Ronald PUD FDP Compliance Review

Planned unit development of a two phased development of attached and detached residences at urban densities (ranging from a possible 30 to 238 units in Phase 1 and 12 to 100 units in phase 2), a possible hotel and active and passive recreation sites.

The Project received preliminary approval on September 7 16, 2011. Ordinance No. 2011-009.

**Exhibit D-1
RONALD PLANNED UNIT DEVELOPMENT
REZONE 07-17
ORDINANCE NO. 2011-009
FINAL DEVELOPMENT PLAN
AUGUST 10, 2021**

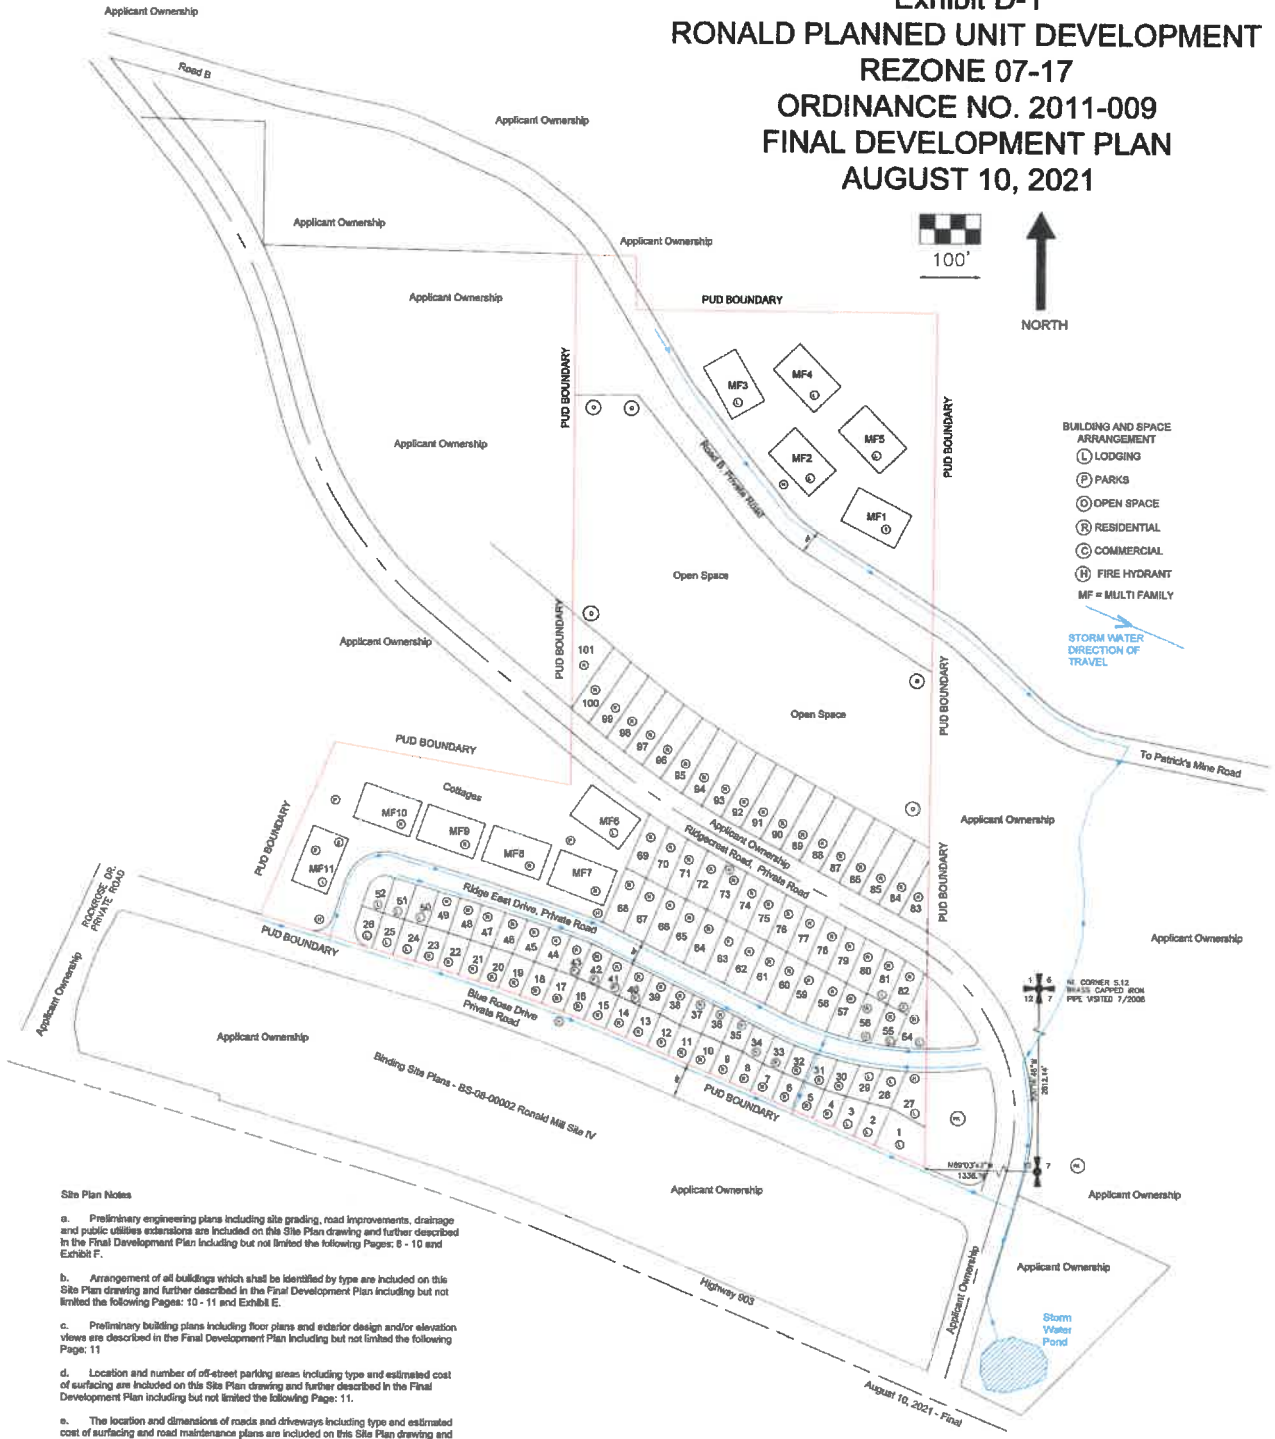
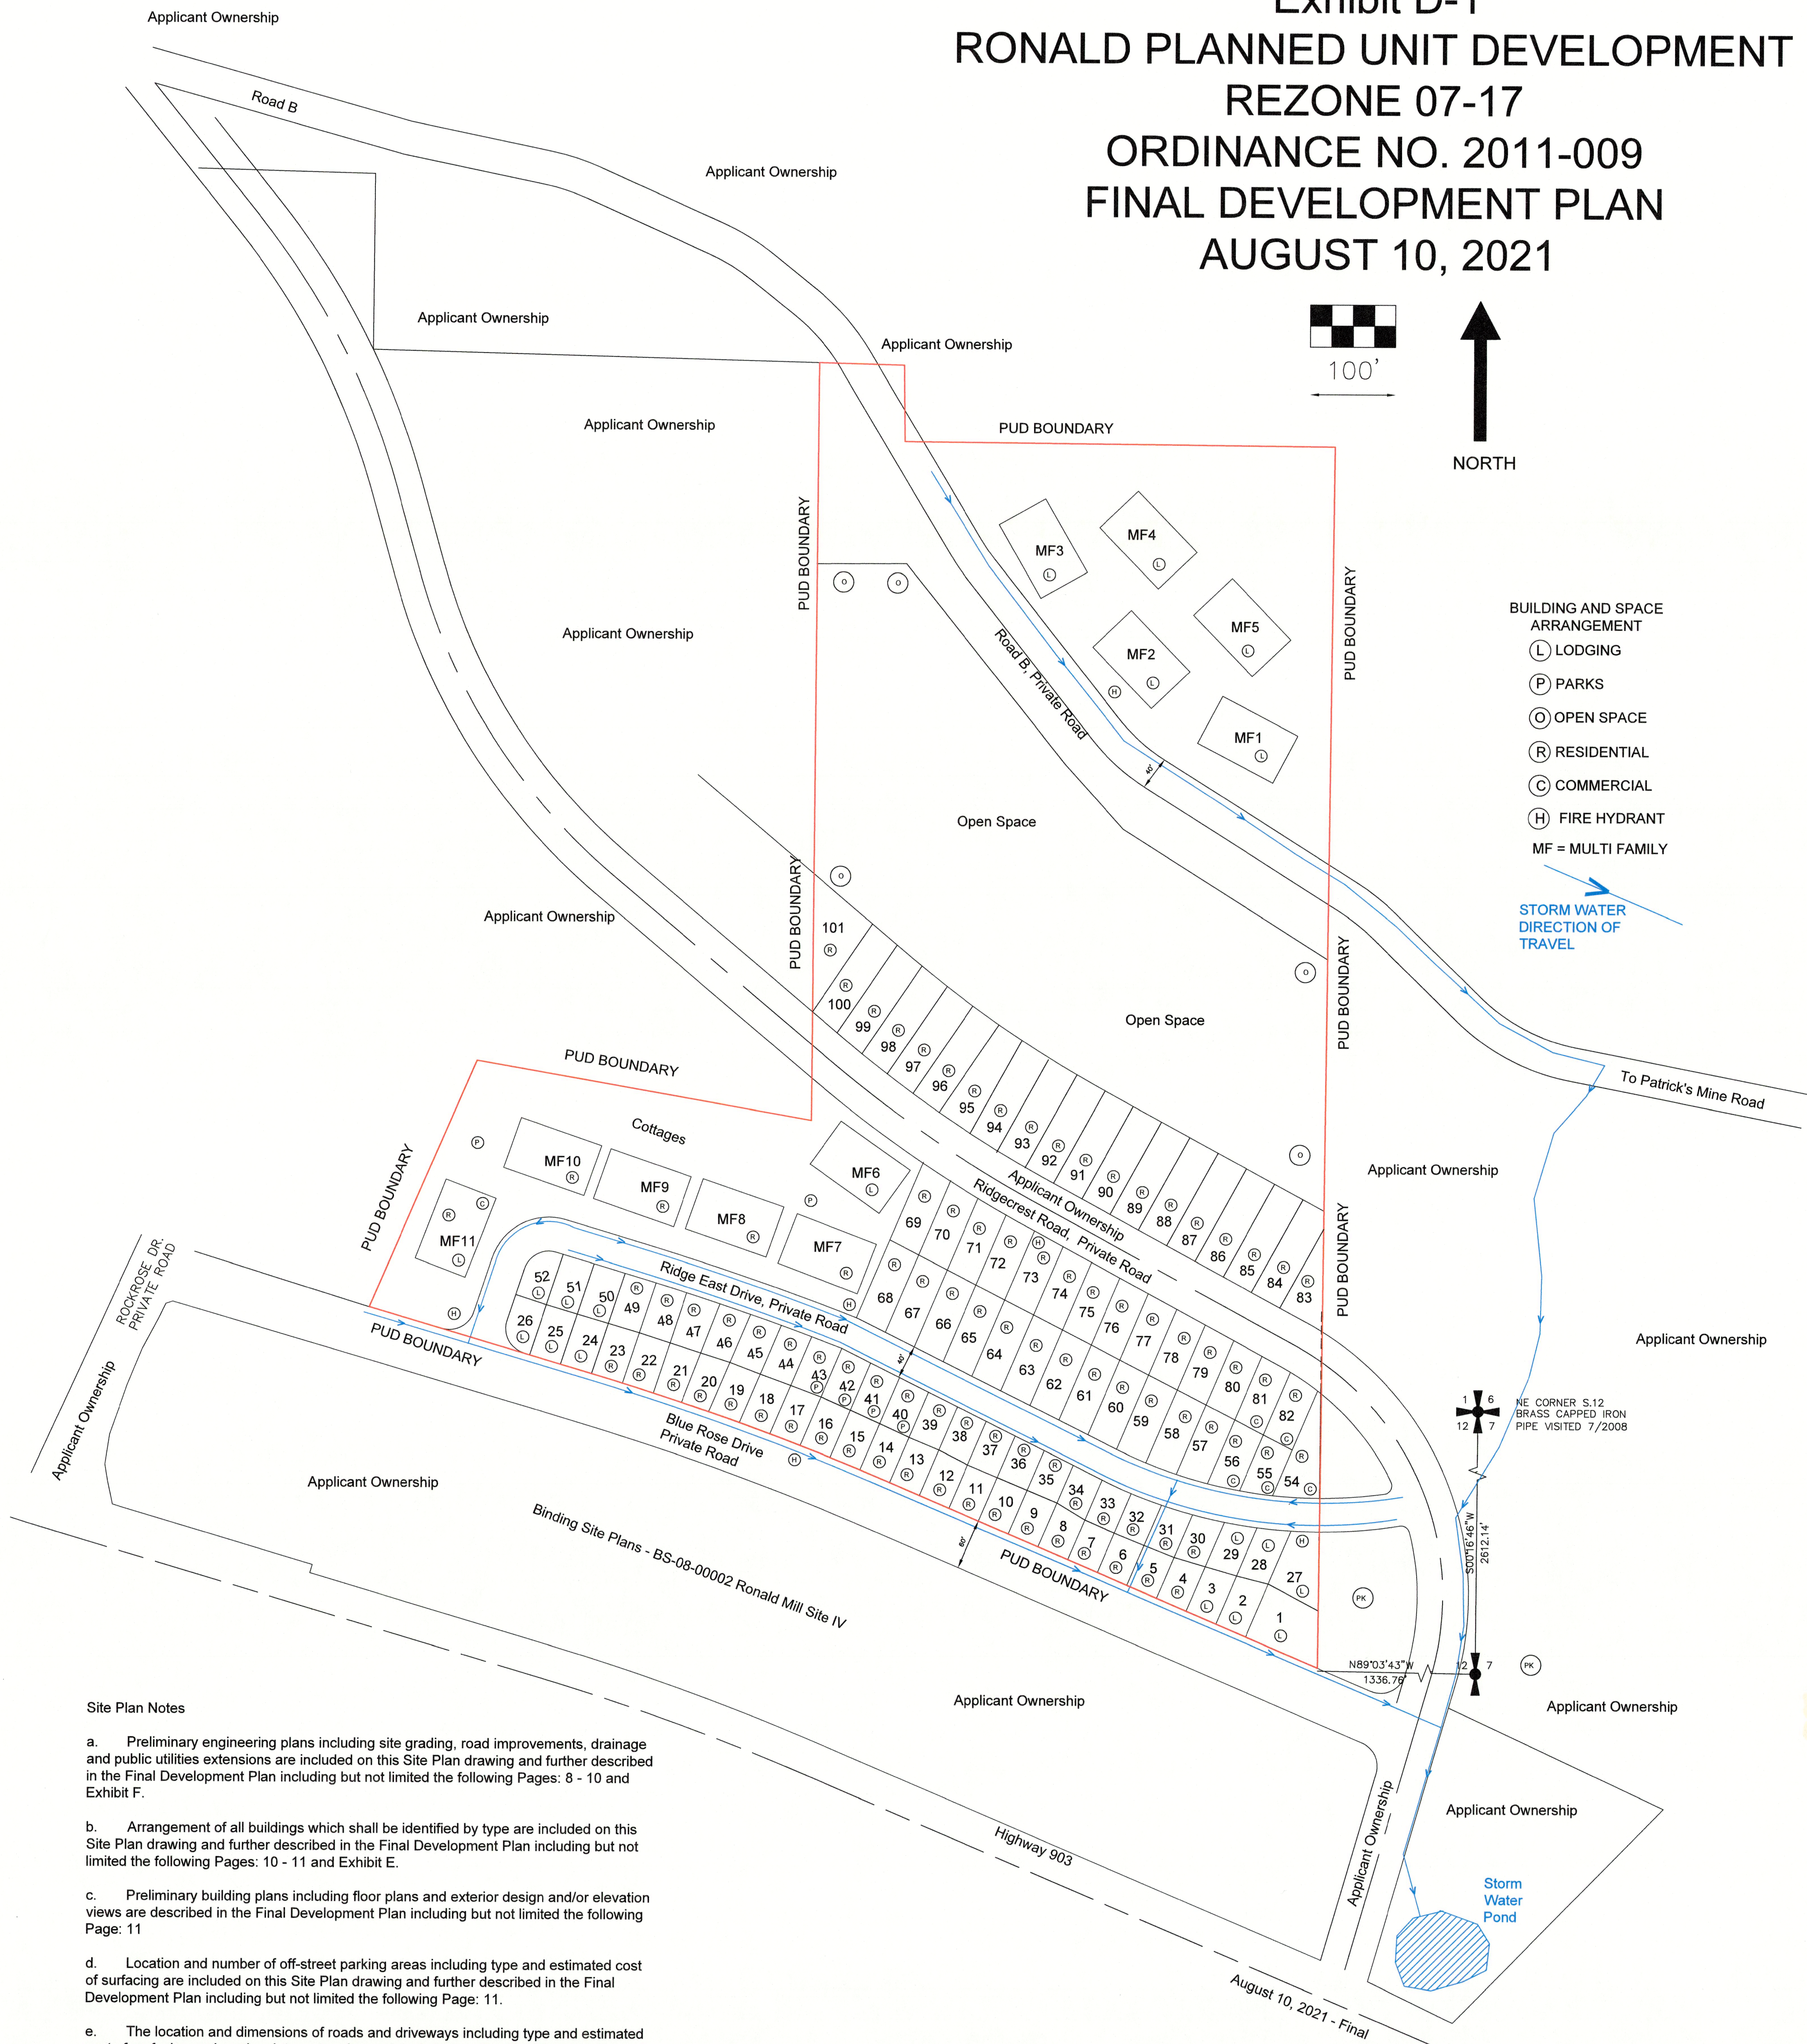
A.	RELEVANT CODE SECTIONS	ANALYSIS	FINDING
A.4	Provisions to assure permanence and maintenance of common open spaces;	Open space location is shown in Exhibit D1 and D2. The applicant states that all common open spaces transfer any required open space to Roslyn Ridge Recreation, LLC for ownership, or successor organization. The applicant states that The Activity Center at Roslyn Ridge Inc. or its successor organization shall manage this open space and other recreational opportunities within the PUD. This will need to be expressed as a plat note for final plat.	Satisfied
A.5	Statement of intent including estimated cost for landscaping and restoration of natural areas despoiled by construction including tree planting. “Great care will be taken by the applicant in regards to the construction of the roads and infrastructure. Where practical all utilities will be placed within the road right of way. The applicant is estimating a cost of \$2.50 per lineal foot of developed road for restoration of areas distributed by construction activities and for landscaping.”	Applicant states all utilities when practical will be placed within the road ROW’s. An estimated cost of \$2.50 per lineal foot of developed road is anticipated for restoration of areas disturbed by construction activities and for landscaping.	Satisfied
